Re: Australian Museum – Alterations and additions (SSD 9452) Notice of Exhibition

I refer to your letter dated 22 October 2018 inviting comments on the above State Significant Development for alterations and additions at the Australian Museum located at 1 William Street, Sydney, in the City of Sydney local government area. The subject site is listed on the State Heritage Register as the Australian Museum (SHR 00805) and is located in the vicinity of various other SHR items listed on the State Heritage Register.

WINDOW SILL RL 24.60

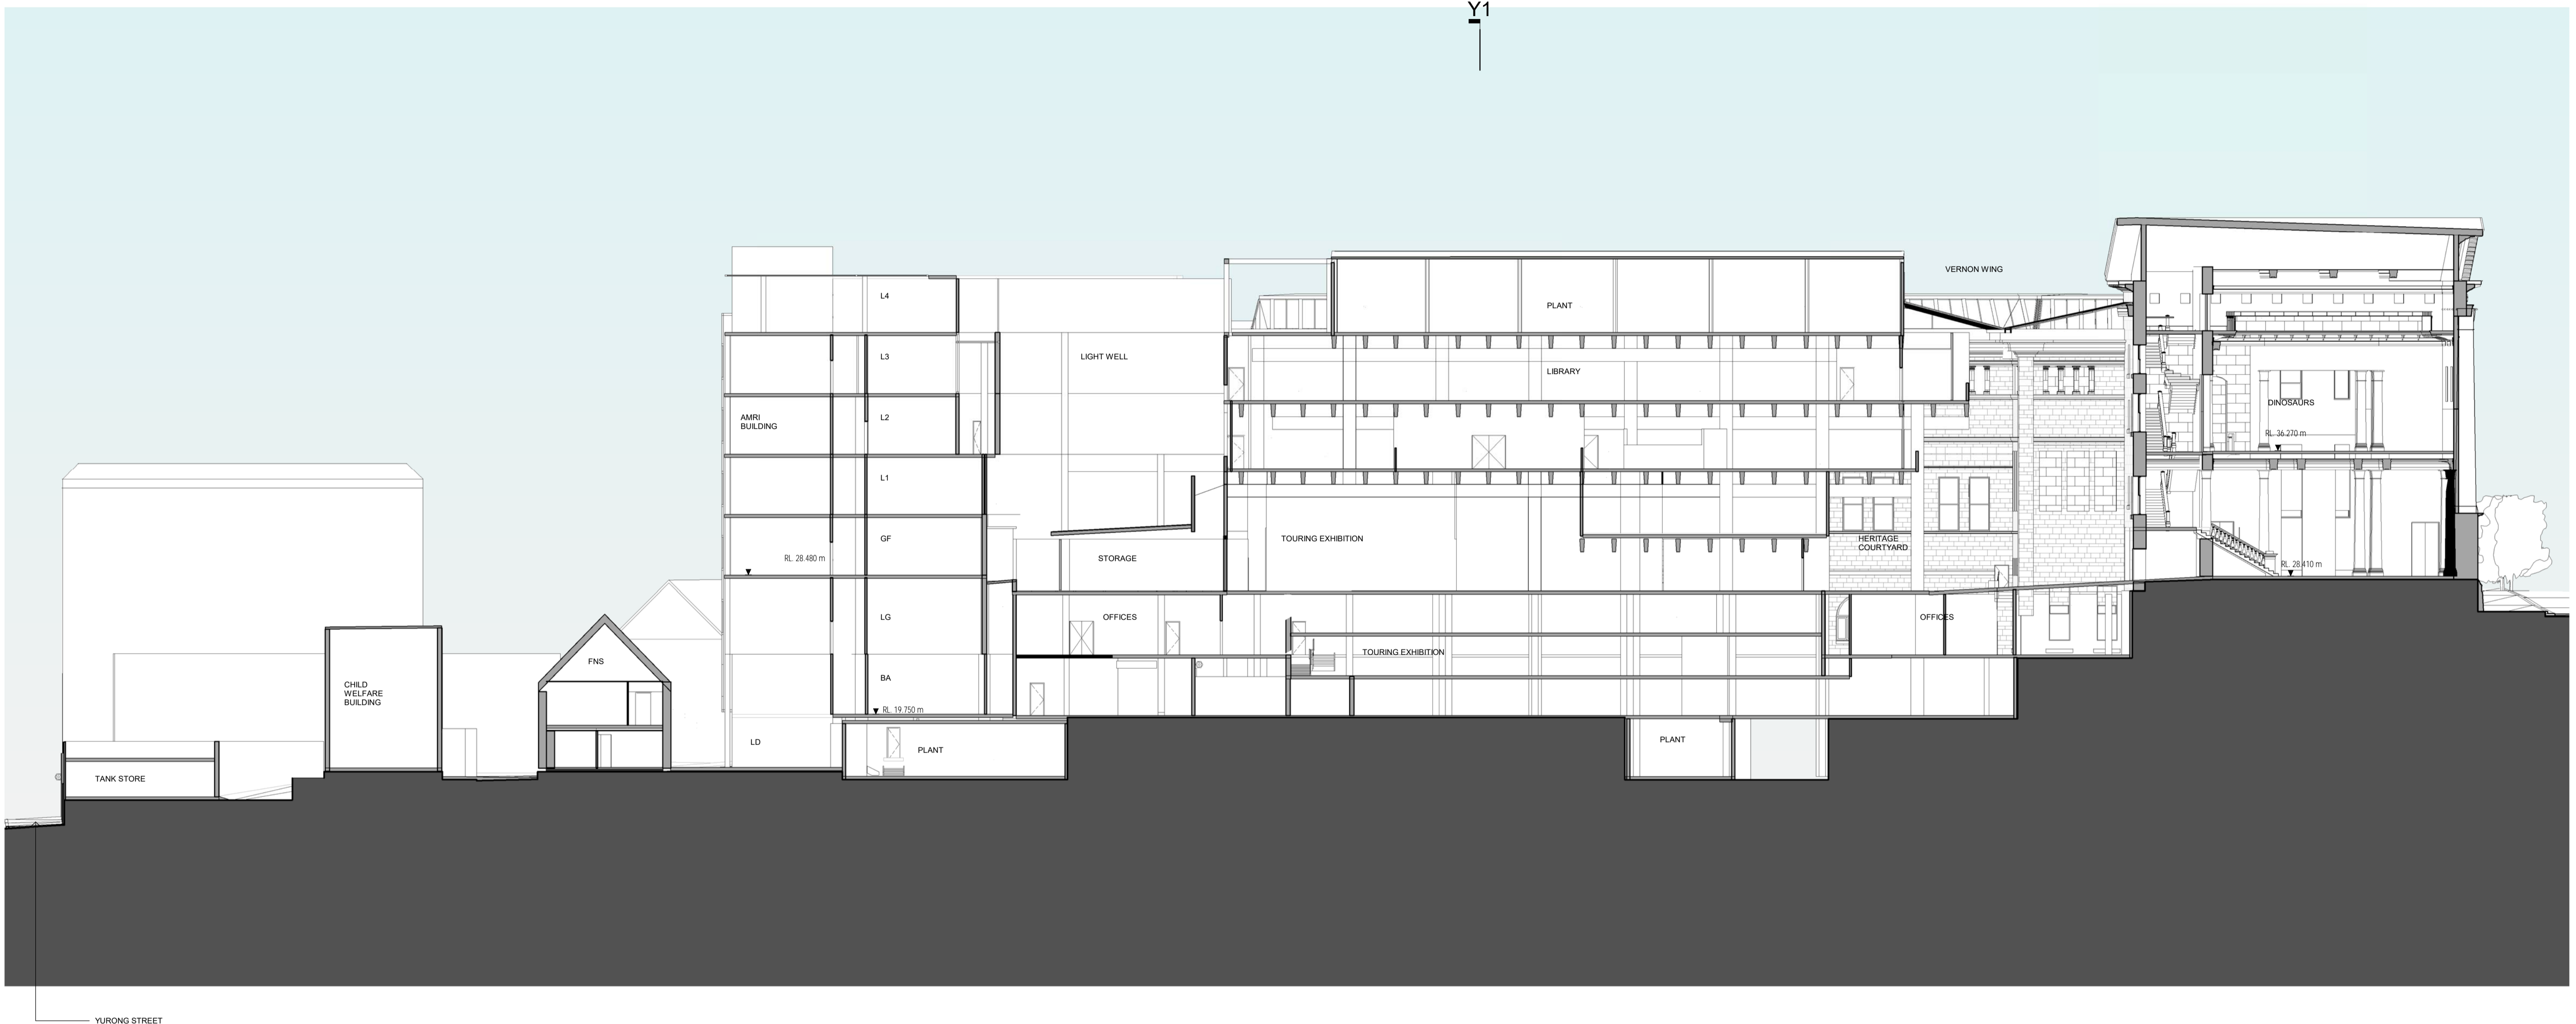
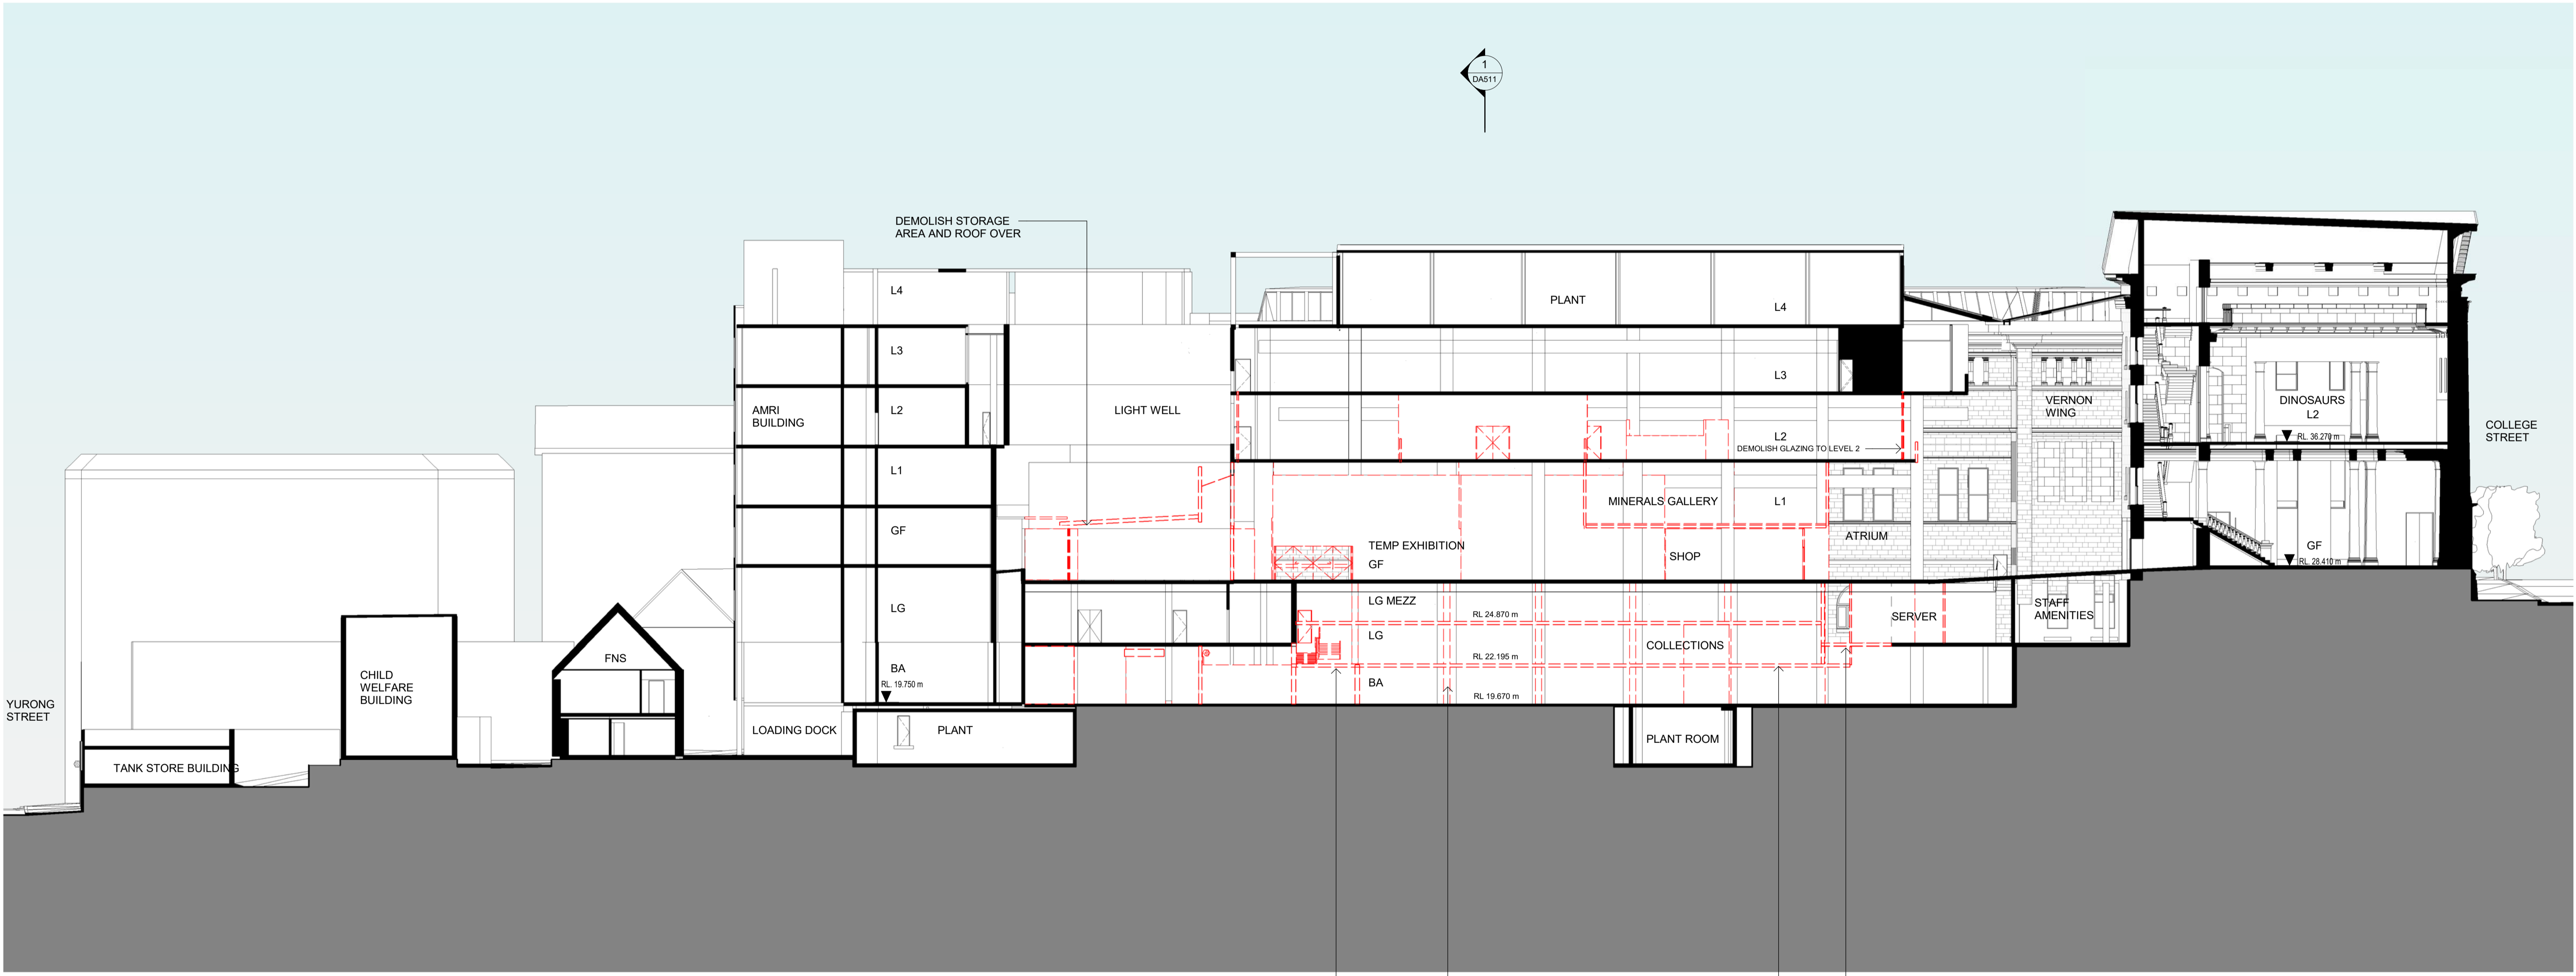
- Consideration should be given, and a methodology prepared to re-use the external stairs of 'medium' significance located north of the Parkes Farmer wing in the construction of the new stair configuration (re-oriented from an east-west to a north-south axis).

- Detailed design for the following aspects of the scope should incorporate measures to minimise heritage impacts and be prepared in consultation with the nominated heritage consultant: new plant room against the rear façade of Barnet wing's lower ground floor; new raised floor along the rear facade of Lewis wings' ground floor; new ramp against the rear façade of Vernon wing's ground floor; rebuilding of lightwell roof
